**Consultation Response from Mike Hibbert,
KC Waste Strategy(Refuse & Recycling)**

**2022/93938 First and Second Floors, Shopping Precinct, New Street and Albion Street,
Huddersfield, HD1 2TR**

**Change of use from A1 (business retail and storage) to C3 (residential) 18 studio flats at first
and second floors and external alterations**

Responding Ref: WPS 22-077 Revised 25.10.2023.

Proposed Ground Floor Plan

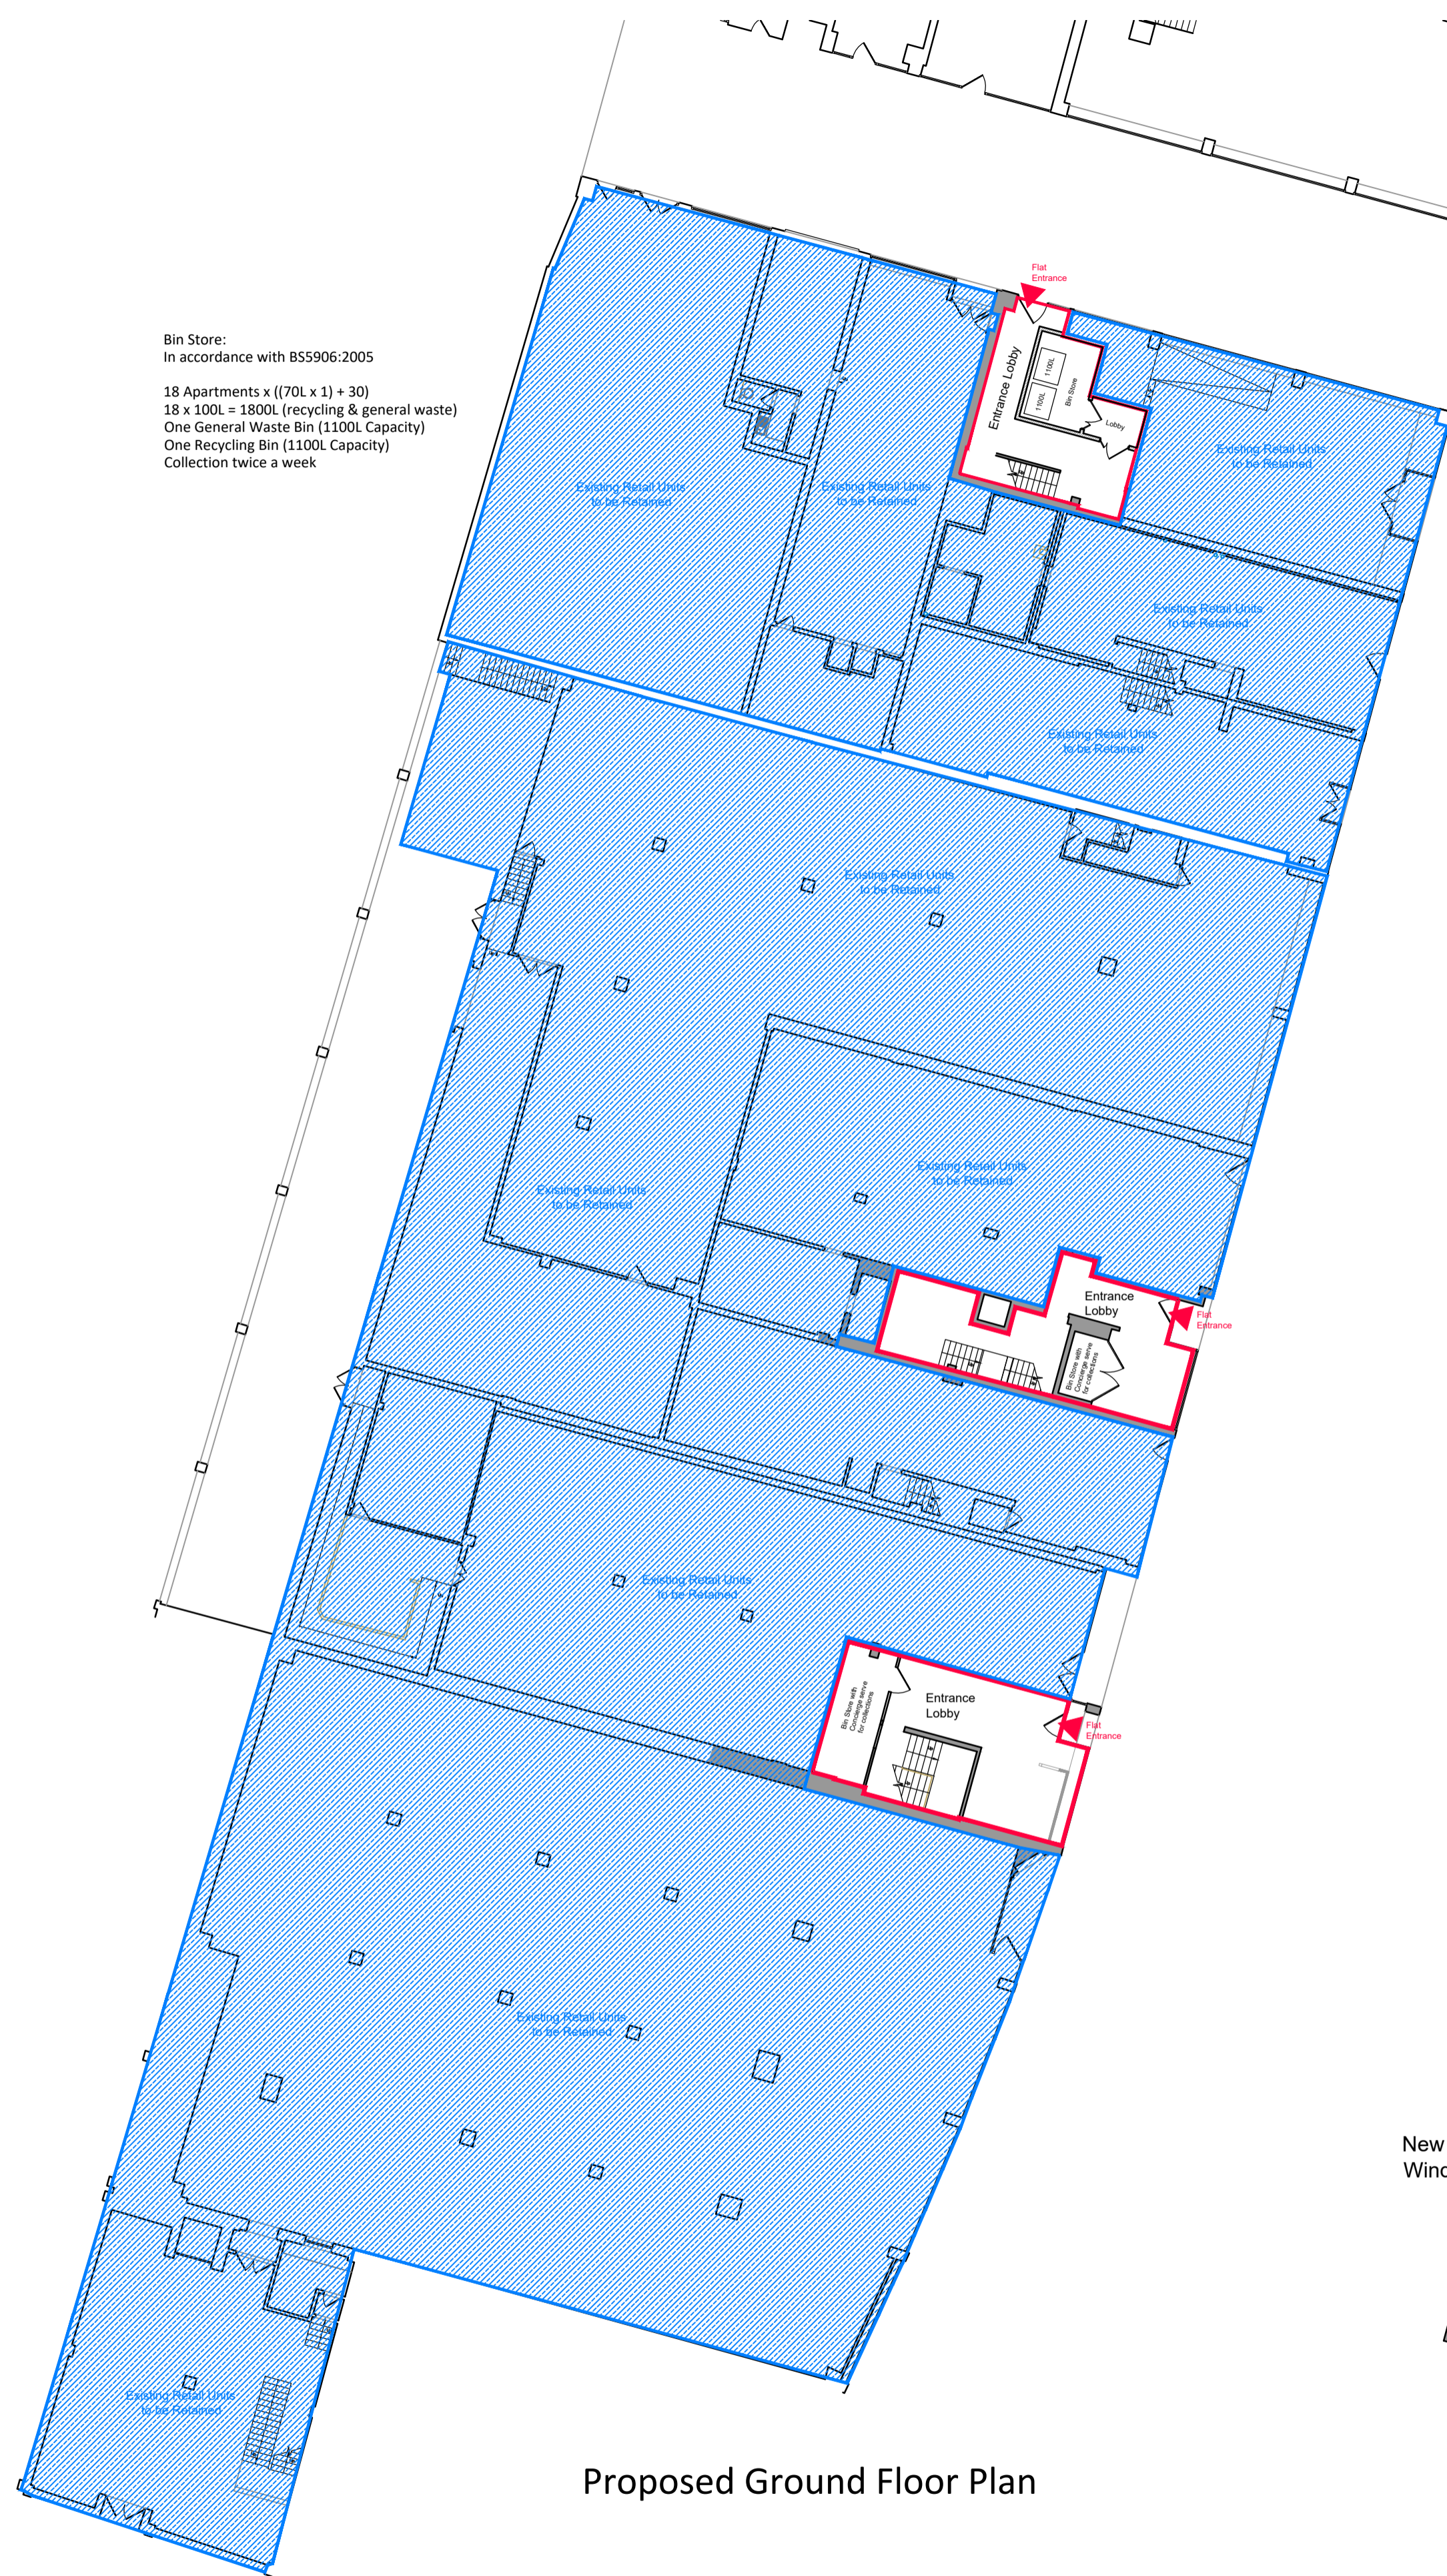
- The waste storage provision for 18 x one-bedroom apartments is 1800ltrs for both residual and recyclates so the proposal to have 4x 1100ltrs wheeliebins is acceptable. In light of the recent announcement by the Government on "Simpler Recycling" thought should be given to provision of storage for food waste. It is noted that applicant is intending to use a private sector waste collection company and frequency of collection may be more than alternate weekly. It is recognised that this could enable the size of the bin store and number of containers to be reduced below that required if the collection regime was alternate weekly collections. Section 45 (1)(a) of the Environmental Protection Act 1990 imposes a duty on the Waste Collection Authority to arrange for the collection of household waste in its area. Regardless of the whether a private collection contractor is used the WCA would wish to ensure there is sufficient waste storage capacity on site, appropriate access, and that if the responsibility for collection falls to the WCA in future that efficient waste collection can be achieved.

- Guidance indicates the floor space for a 1100ltrs wheeliebins is 1575mmx1190mm with space to manoeuvre the bins within the store so the bin store dimensions would depend on configuration within the store. The internal bin store dimensions appear to be 2m x 5.3m and therefore maybe too small to accommodate four x1100ltrs wheeliebins. The door to the store is approximately 1m wide so may need adjusting to enable easy passage of a wheeliebin.

- An internal bin store presents a fire risk and must comply with fire regulations (refer to BS 5906:2005 Waste Management in Buildings; Building Regs 2010 Part H6, CFPA-E Guideline No 7:2022 F, BS476-22:1987: Fire tests on building materials and structures; and BS EN 1634-1:2008: Fire resistance and smoke control tests for door, shutter and openable window assemblies and elements of building hardware for internal compounds.

- BS5906:2005 states “Waste storage chambers should preferably be away from the main entrance to the building and should be constructed such that containers can be removed directly to the outside, without passing through any part of the building served by the chamber except by way of passage.” On this basis the applicant should consider whether to relocate the waste store within the entrance lobby such that so there is residents’ access from inside the building and direct access to the highway for waste collection.

- The bin storage area and access routes to the Bin Collection Point (BCP) should be constructed to withstand point loading and movement, impacts of larger bins over time, and to resist future rutting, pitting, cracking or other such surface degradation that would impair bin manoeuvring. To facilitate loading of full wheeliebins the surface between the bin store and BCP/ highway should be smooth hard surface without kerbs. The proposed layout must ensure that parked cars do not obstruct the route between the bin store and loading point.
